CITY OF ALBUQUERQUE

December 29, 2004

**Re: Church's Chicken, 2307 Juan Tabo Blvd NE, Traffic Circulation Layout
Architect's Stamp dated 12-21-04 (H21-D48)**

PROPOSED NEW
TRAFFIC PLAN

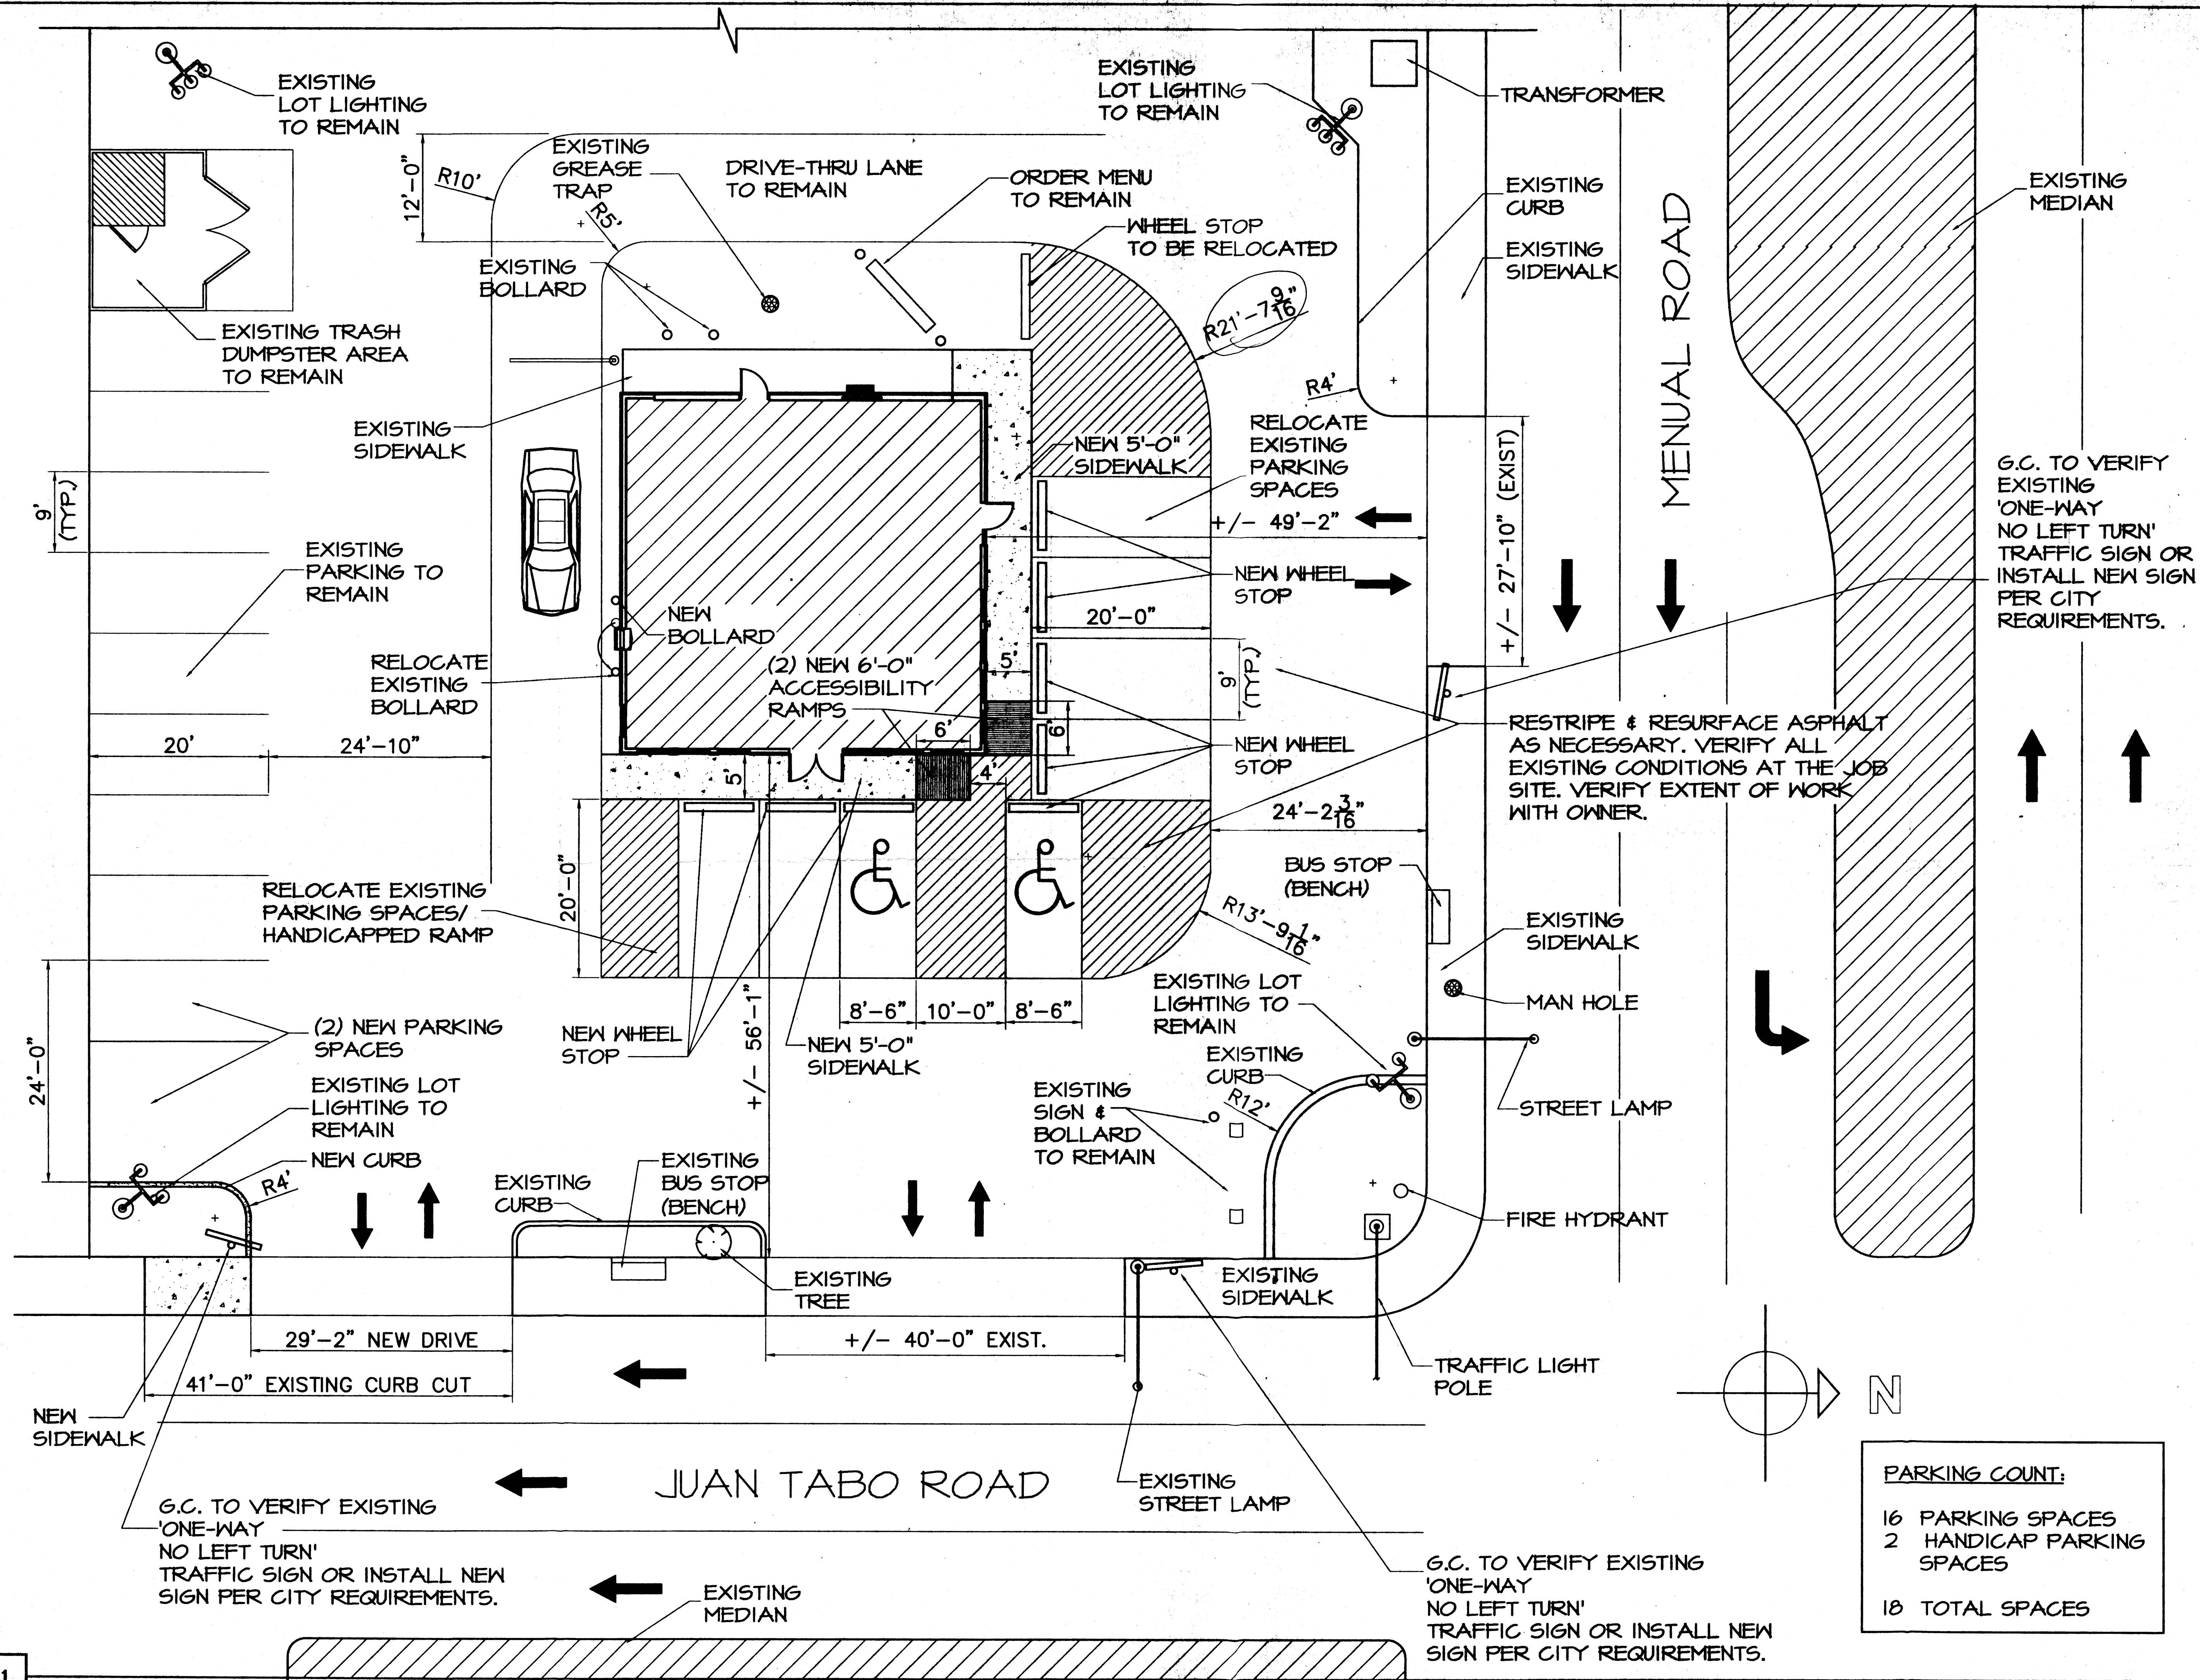
1. Please refer to all applicable city standards.
2. Please show a vicinity map on the Traffic Circulation Layout.
3. List the number of parking spaces required by the zoning code as well as the proposed number of parking spaces.
4. For passenger vehicles, the minimum end island radius is 15 feet. Show how vehicles will travel through the drive-thru lane without interfering with adjacent traffic.
5. Check the scale the Traffic Circulation Layout is drawn at.
6. Indicate all existing areas and clearly show what is proposed.
7. Remove the northern drive on Juan Tabo Blvd. It is located too close to the intersection.
8. The sidewalk should be 6 feet in width. Note that the 2-foot overhang is not allowed to encroach on the 6 foot required width of sidewalk.
